**WELWYN HATFIELD BOROUGH COUNCIL
EXECUTIVE DIRECTOR - PLANNING, PUBLIC PROTECTION AND GOVERNANCE**

DELEGATED APPLICATION

Application No: 6/2018/1107/LAWP
Location: Manor Cottage Vineyards Road Northaw Potters Bar EN6 4PQ
Proposal: Certificate of lawfulness for the erection of side extension and outbuilding
Officer: Ms Lucy Hale

Recommendation: Refused

**PROJECT ADDRESS:**  
Outbuilding

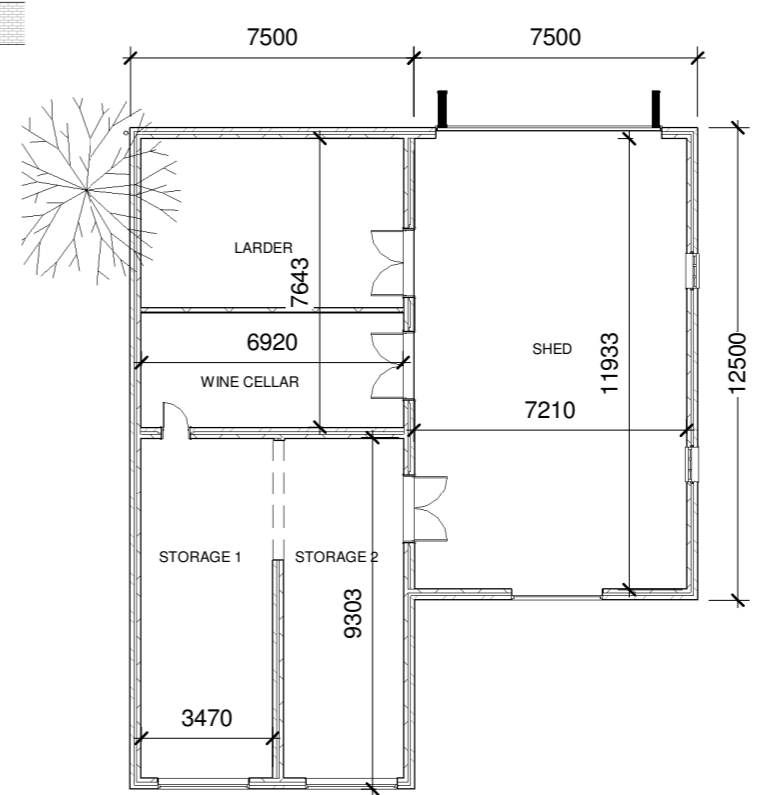
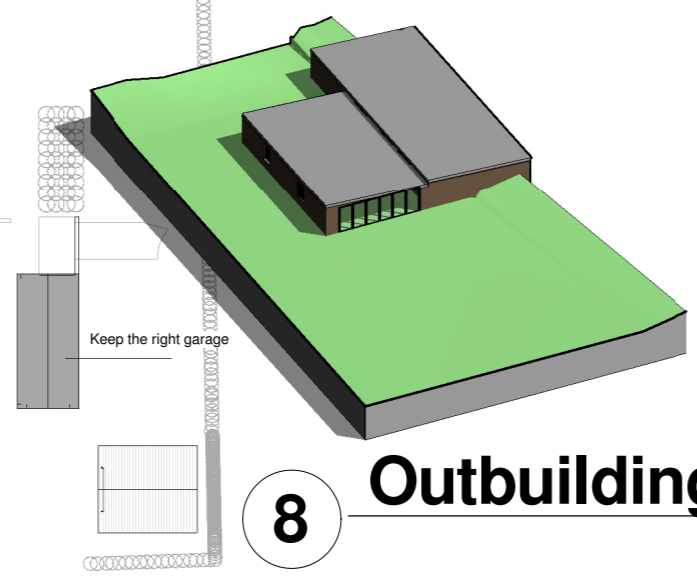
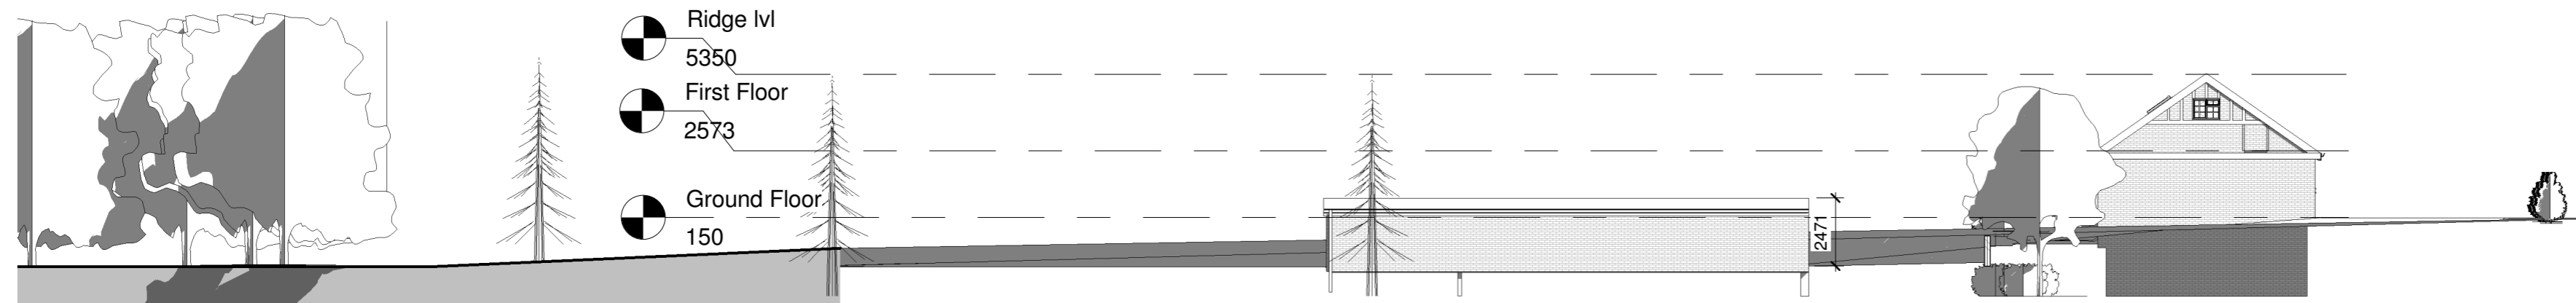
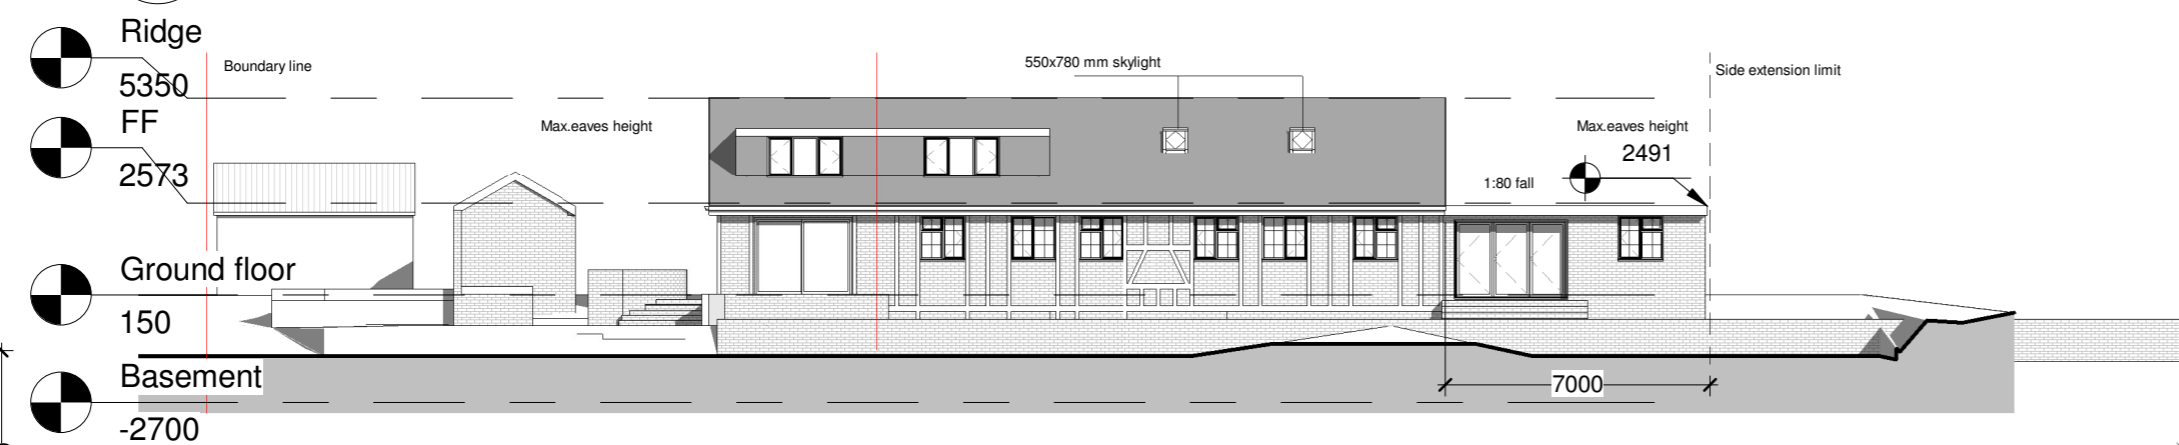
The proposed outbuilding would be situated within the rear garden of the application site and would measure approximately 227 square metres. It would accommodate a wine cellar, larder, shed and two storage areas. The proposed shed would measure 7.2 metres by 11.9 metres internally, storage 1 would measure 9.3 metres by 3.4 metres and storage 2 would measure 9.3 metres by 3.1 metres. The proposed larder would measure 6.9 metres by 4.3 metres and the wine cellar would measure 6.9 metres by 3 metres.

The existing dwelling has a footprint of 169 square metres. The proposed outbuilding would have a larger footprint than the existing dwelling, over and above its size by 34%, and therefore, when compared to the existing dwelling, the outbuilding is considered to be significant in size. Size alone is not necessarily a determining factor, however, it is an important factor to take into account. A wide range of outbuildings, for different purposes may be permitted under Class E, depending on the specific circumstances. Those principles have been established through the Courts, including the cases of Emin and Wallington. The Courts have also established that the term 'required' should be interpreted as meaning 'reasonably required'.

Whilst the proposed use of the outbuilding which includes a shed, storage area, wine cellar and larder, are considered to be uses that may be incidental to the main dwelling under Class E, the key test is whether the proposed outbuilding is reasonable for its intended purpose. The proposed size of the outbuilding is very large for its intended use and no details, other than an annotation on the drawing labelling the use of each room has been provided. Furthermore, no justification has been submitted to demonstrate why the building and proposed uses of that building, of such size, is required.

Without an explanation of the intended uses so as to make clear the justification of the size and scale of the building, it cannot be ascertained that the outbuilding is reasonably required for purposes incidental to the enjoyment of the dwelling. The proposed outbuilding therefore fails to accord with Schedule 2, Part 1, Class E of the Town and Country Planning (General Permitted Development) (England) Order 2015 as amended.

The proposed outbuilding, by virtue of its size, would not be reasonably required for a purpose incidental to the enjoyment of the dwellinghouse. No justification has been submitted to demonstrate why a building of such size is required. This building therefore fails to accord with Schedule 2, Part 1, Class E of the Town and Country Planning (General Permitted Development) (England) Order 2015 as amended.

1. The proposed outbuilding, by virtue of its size and failure to demonstrate why such size is required for the intended use, is not considered to be reasonably required for a purpose incidental to the enjoyment of the dwellinghouse Accordingly, the Certificate of lawfulness fails to accord with Schedule 2, Part 1, Class E of the Town and Country Planning (General Permitted Development) (England) Order 2015 as amended and is refused.
